Our ref: 214198-WSP-SYD-CIV-LTR-02 Rev03

24 March 2025

### **DPHI and CPHR RtS Response Letter**

WSP have sought to amend the Stormwater Management and Flood Impact and Risk Assessment Report (214198-WSP-SYD-CIV-REP-01) in response to the Response to Submissions (RtS) provided by DPHI and CPHR (SSD-71687208 ref: DOC25/111734). Below responds to each of the concerns raised by DPHI with reference to the amended Stormwater Management and Flood Assessment Report.

Overland Flow Path Sections

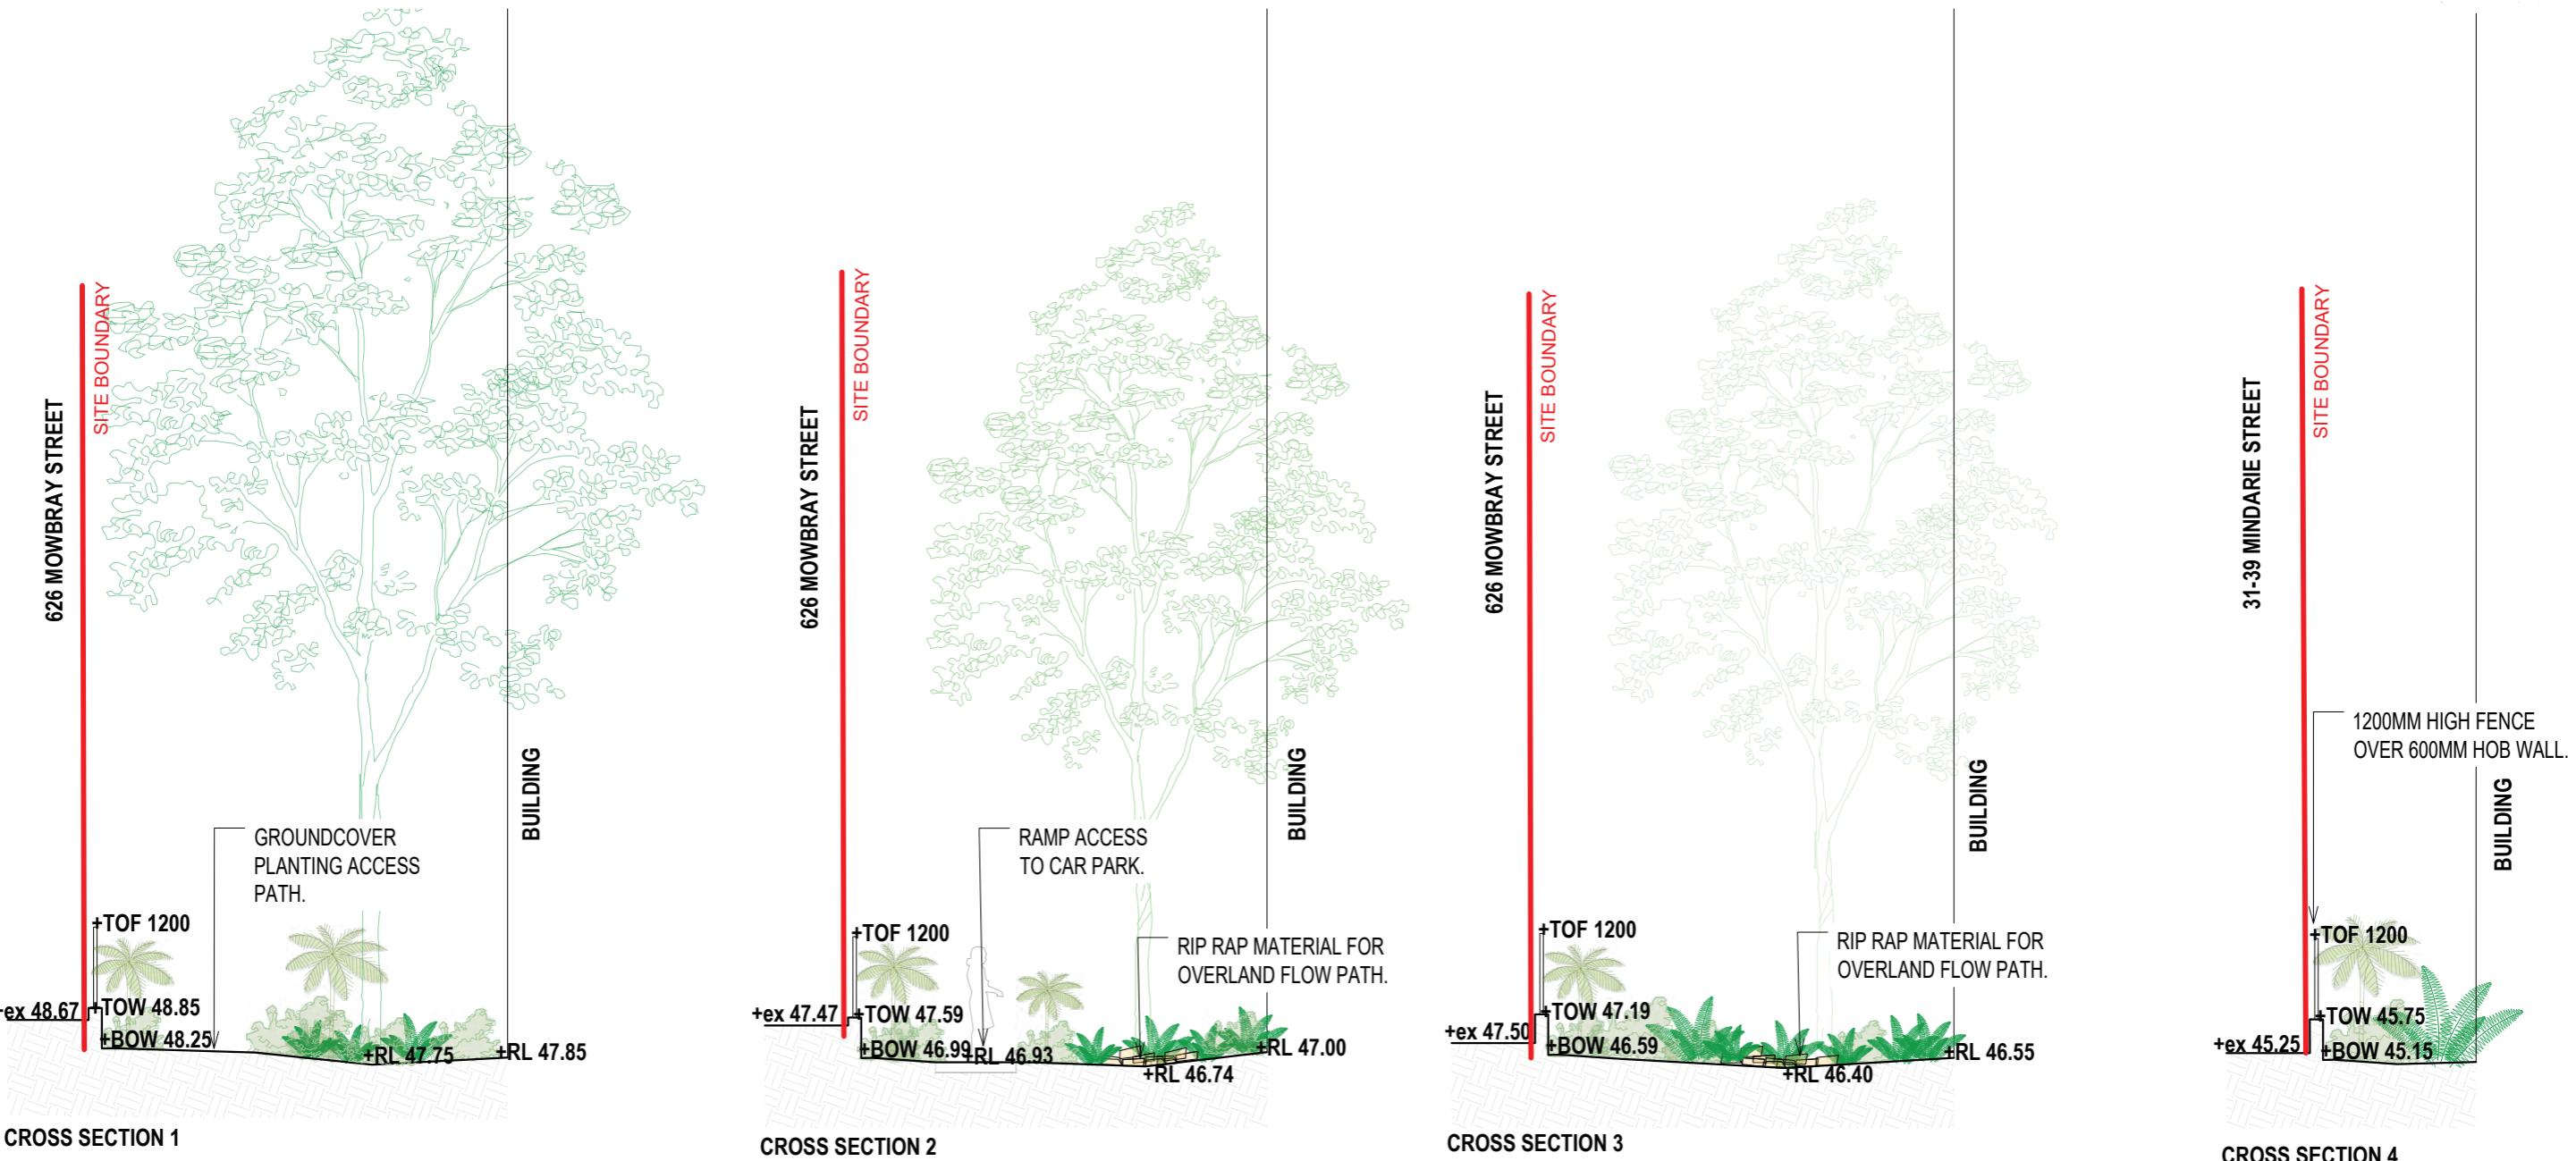
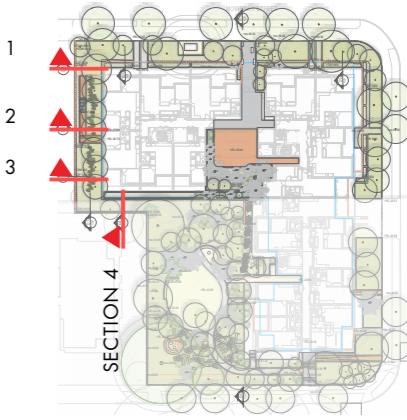
<b>Key Assessment Issues</b>	<b>Response</b>
<p><b>Inconsistency in provided documents</b></p> <p>CPHR notes that the landscape plans have been updated to show rip rap to the overland flow path. However, the landscape plans show a landscaped retaining wall across the flow path. The flood mapping appears to demonstrate a continuous gradient in this area and no drop pit has been provided in the stormwater pipeline to indicate a change in level. The RTS notes depths of 0.25 m at 2 m/s will flow in the overland flow path in an event as frequent as the 5% event which would be considered H5 hazard. This is not consistent with the provided flood mapping.</p> <p>Recommended action:</p> <ul style="list-style-type: none"> <li>• Check the FIRA and landscape plans for consistency and provide results in a manner which clearly describes expected flood behaviour and how this risk is managed.</li> <li>• Prepare landscape cross sections and long sections for the constrained overland flow path down the side of the building which can be modelled in the FIRA. This is requested to ensure that the same design criteria are applied to flood modelling, stormwater design and landscape/architectural design.</li> </ul>	<p>The landscaped swale long section and cross sections have been reviewed, and the model has been updated to more accurately reflect the overland flow path. This ensures alignment between the FIRA and landscape plans in demonstrating expected flood behaviour and risk management.</p> <p>Refer to Section 2.3.2 of the report for details on the updated modelling</p> <p>The landscape design of the swale has been incorporated and is provided in Appendix A</p> <p>The updated assessment confirms that the design results in no adverse impact on the adjacent properties.</p>
